Addendum

No. 1

Description: Revise front line beverage casework to accept cart. Separate eyewash from handsink per Code review comments.

Project Title Sheetz C-Store
Sawyer Road
Cameron, NC

A810

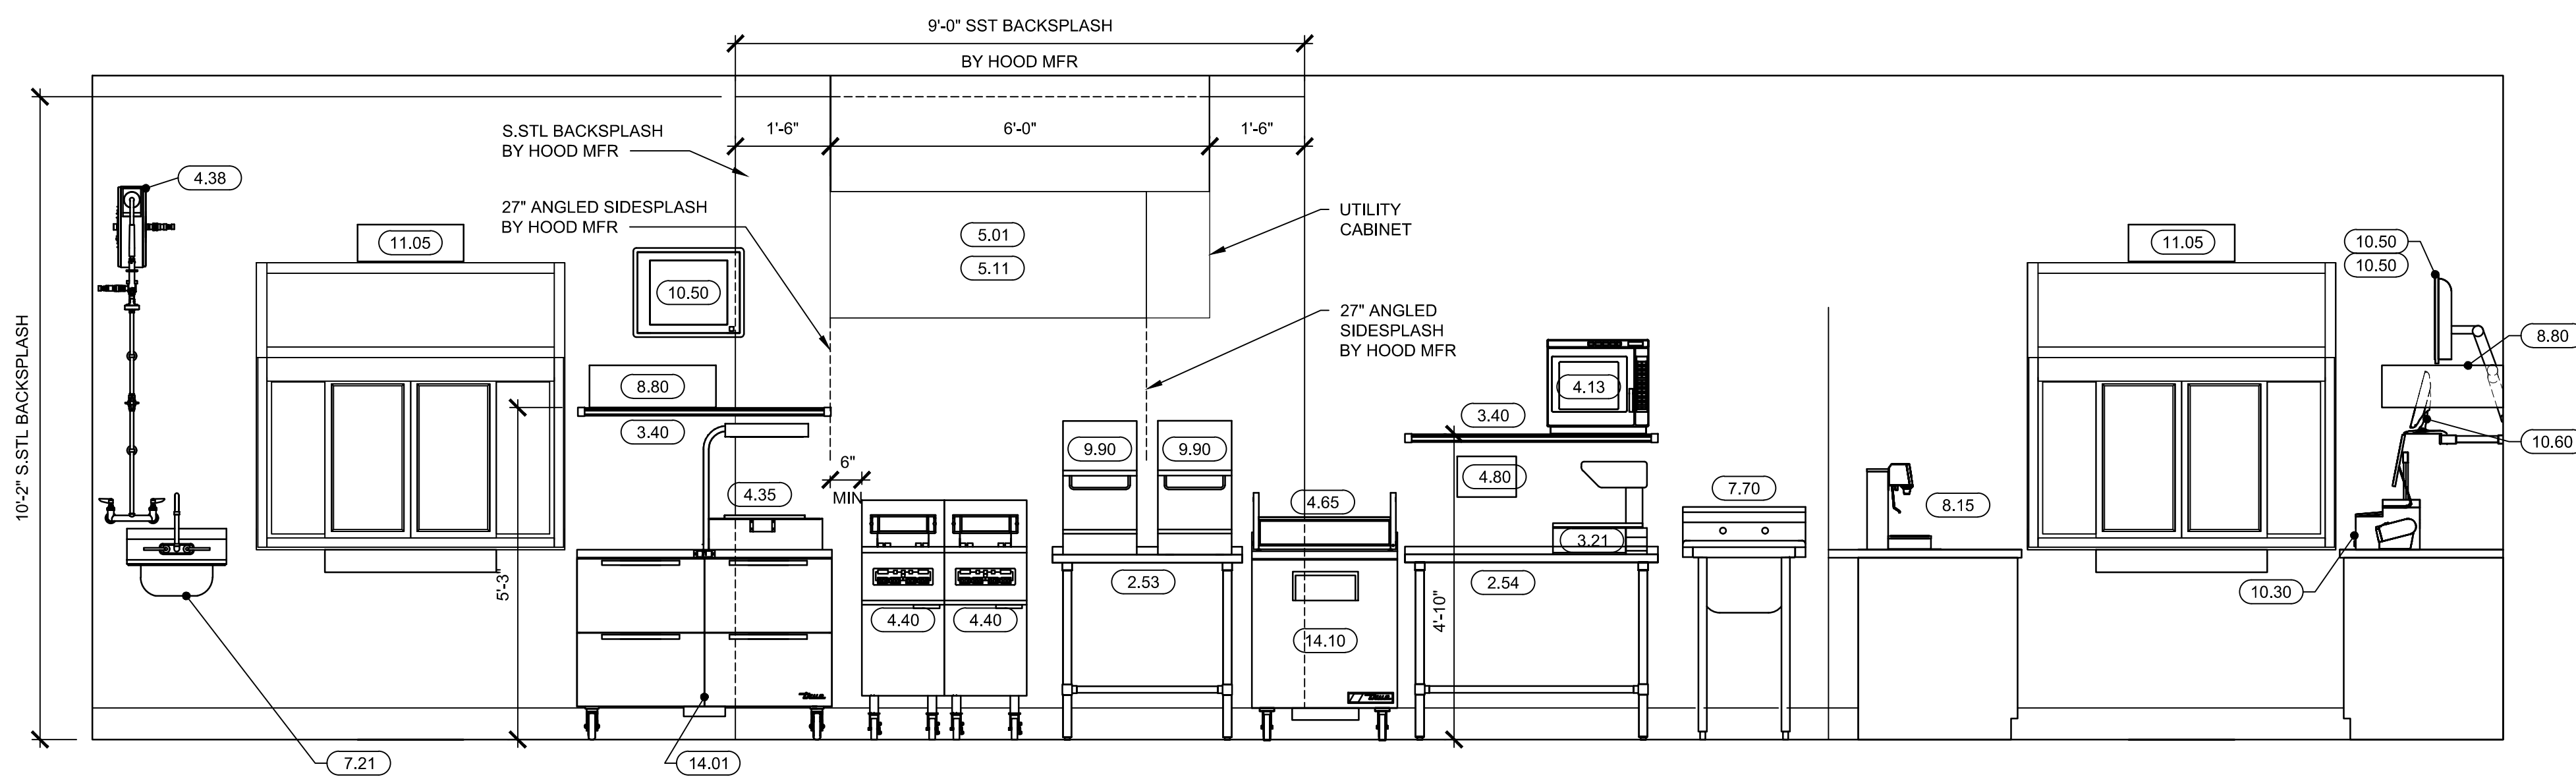
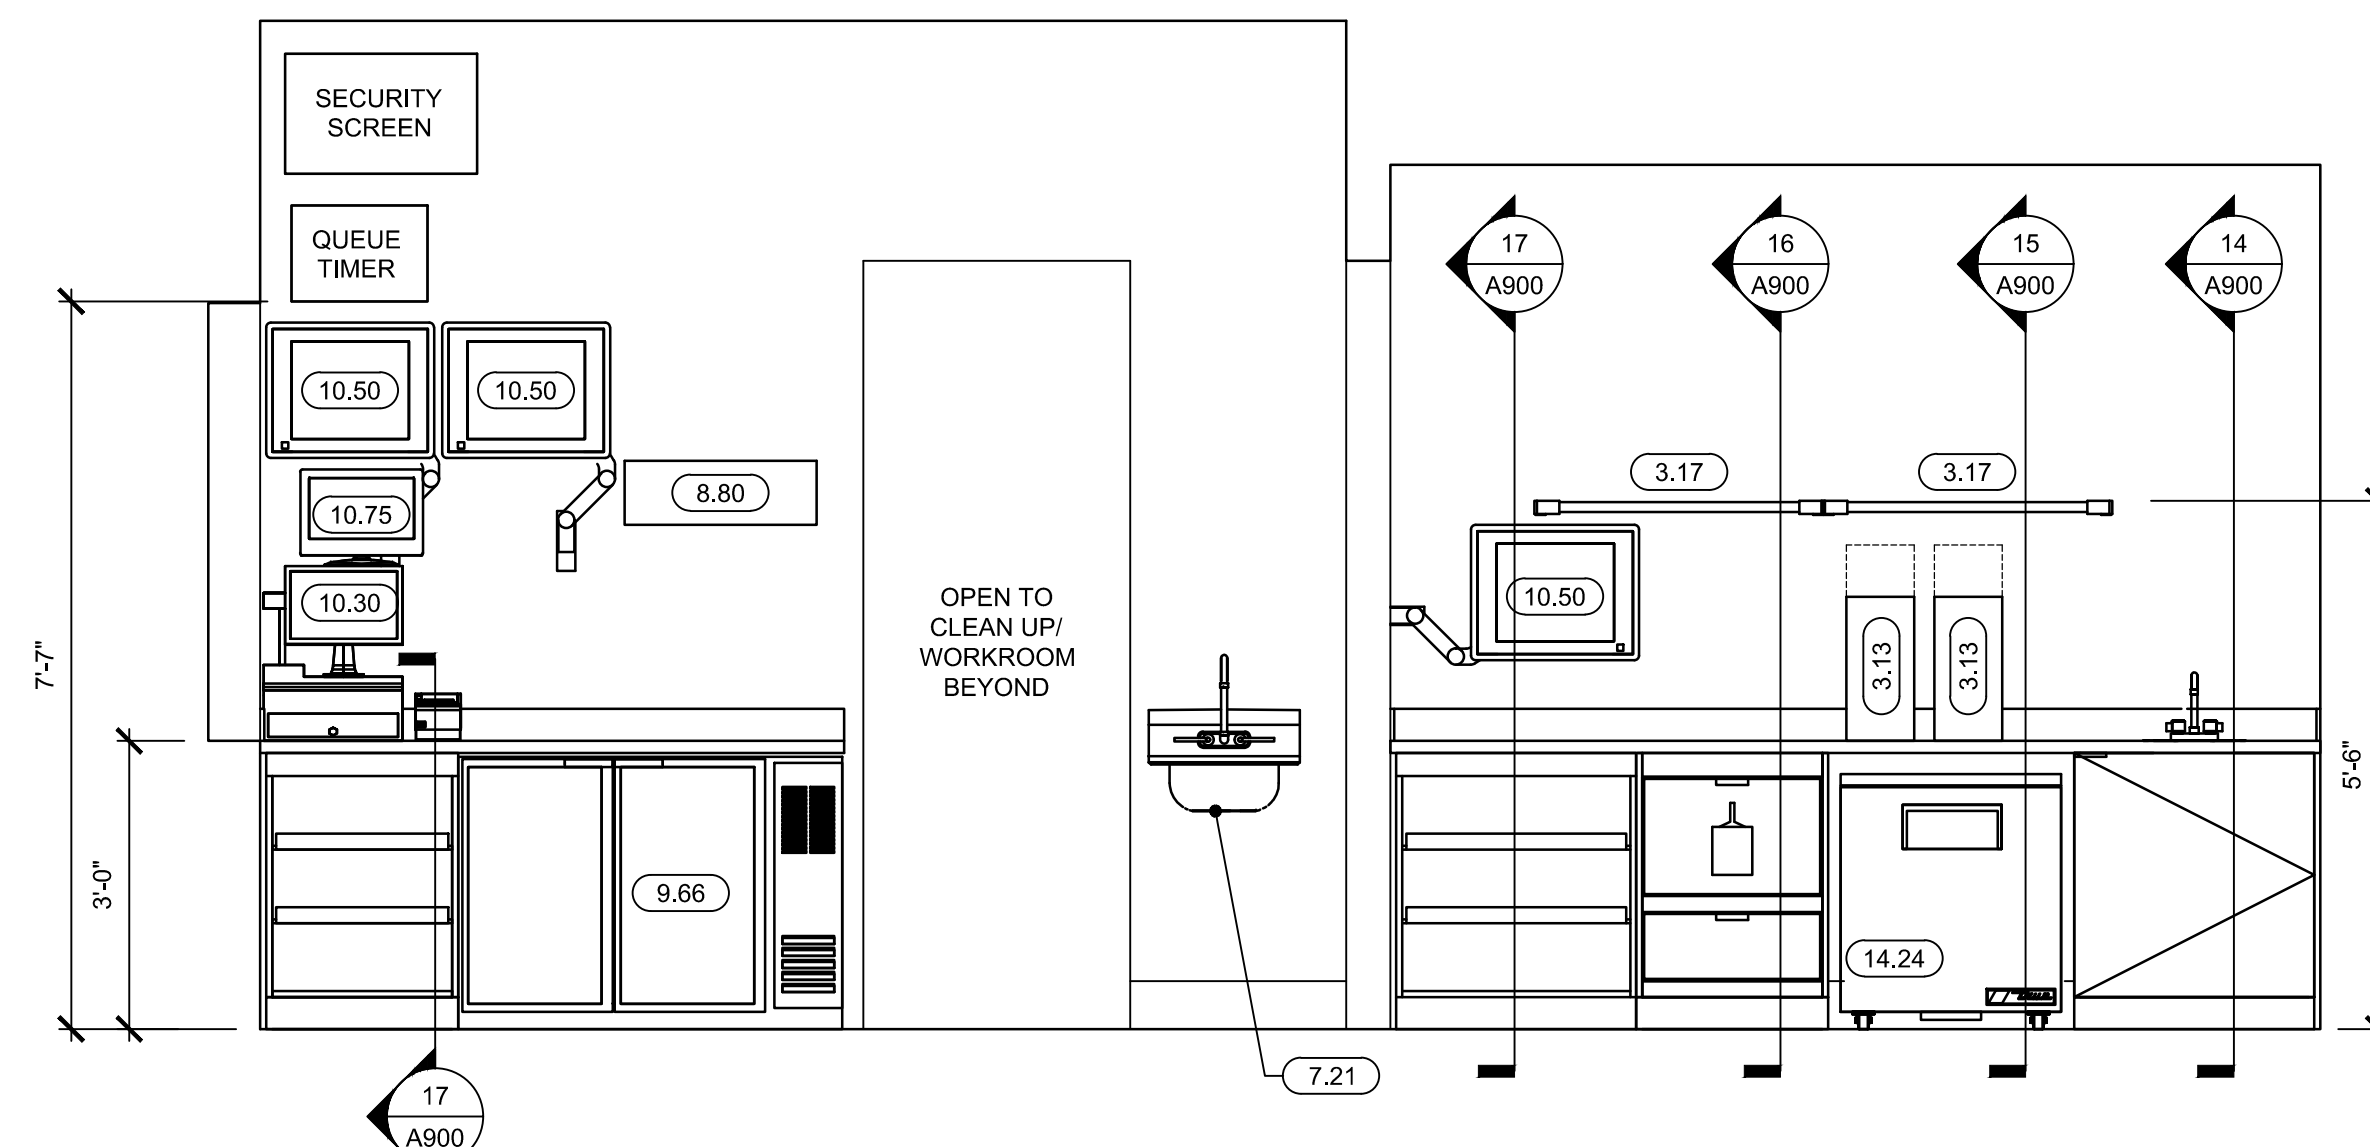
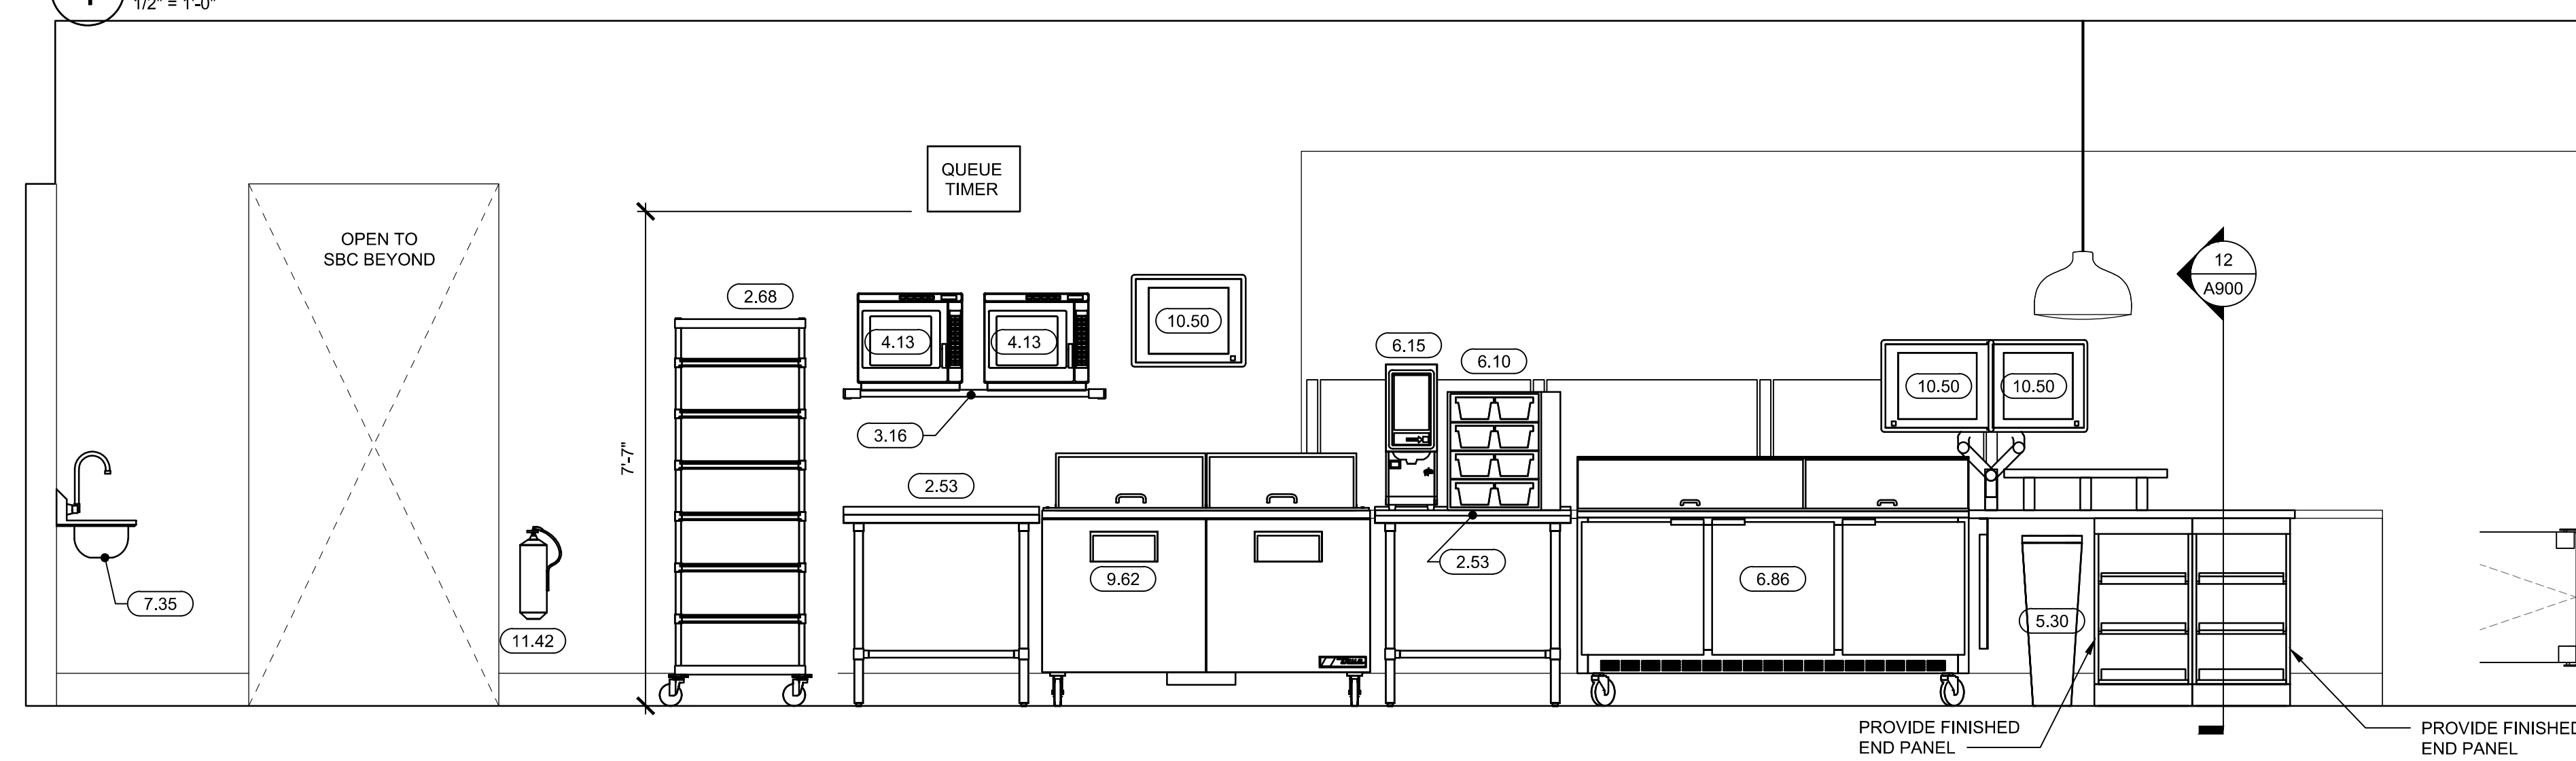
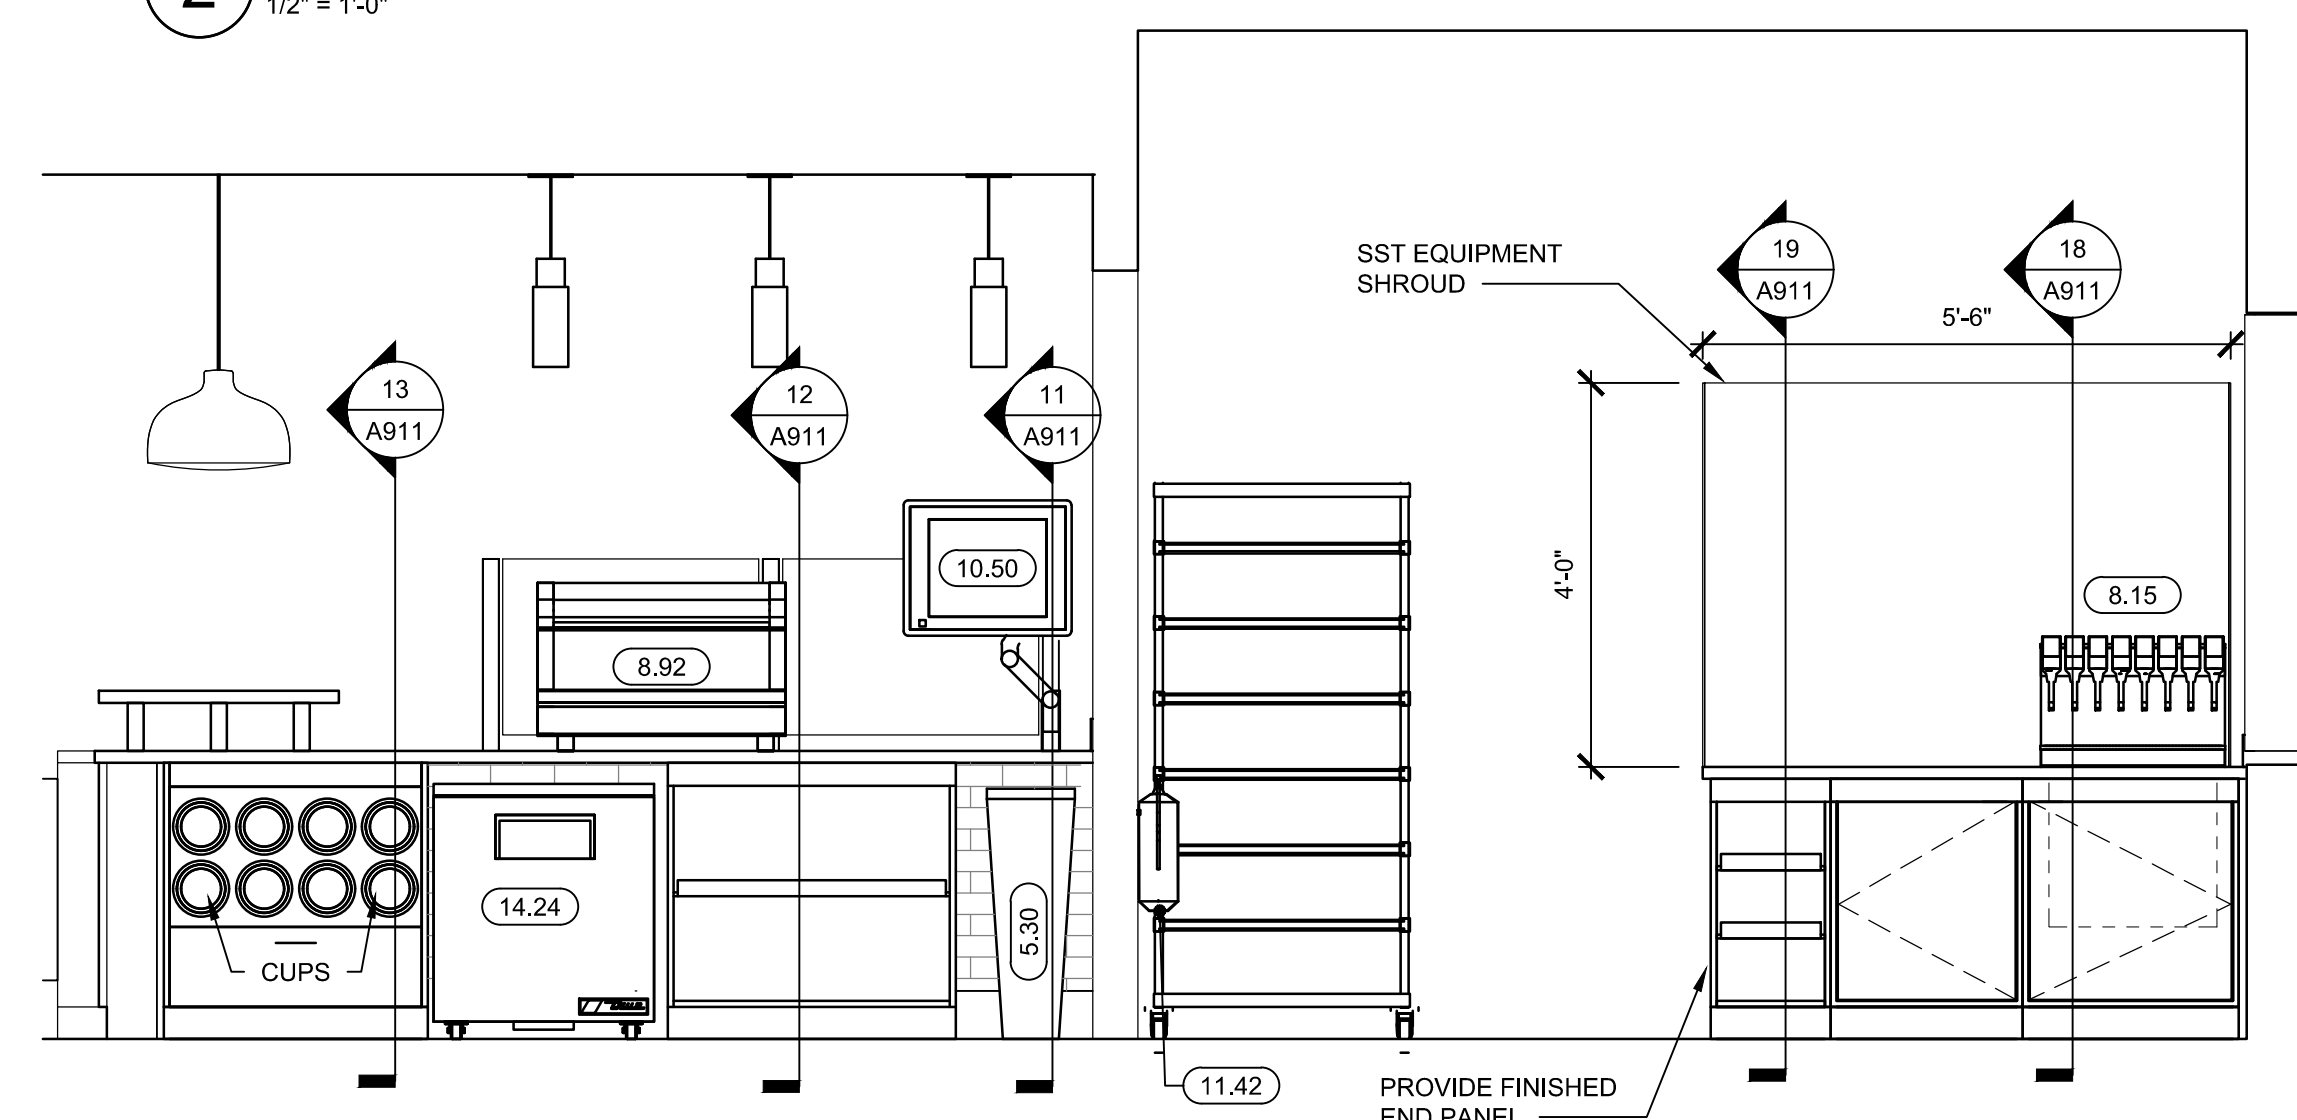
- Item 1: *A800 - EQUIPMENT PLAN- Revised beverage bar countertop. Separated eye wash from sink.*
- Item 2: *A810 - EQUIPMENT ELEVATIONS & DETAILS- Revised beverage bar elevation.*
- Item 3: *A900 - CASEWORK PLANS, ELEVATIONS & DETAILS- Added access panel note to detail 4.*
- Item 4: *A920 - CASEWORK PLANS, ELEVATIONS & DETAILS- Revised beverage bar countertop.*
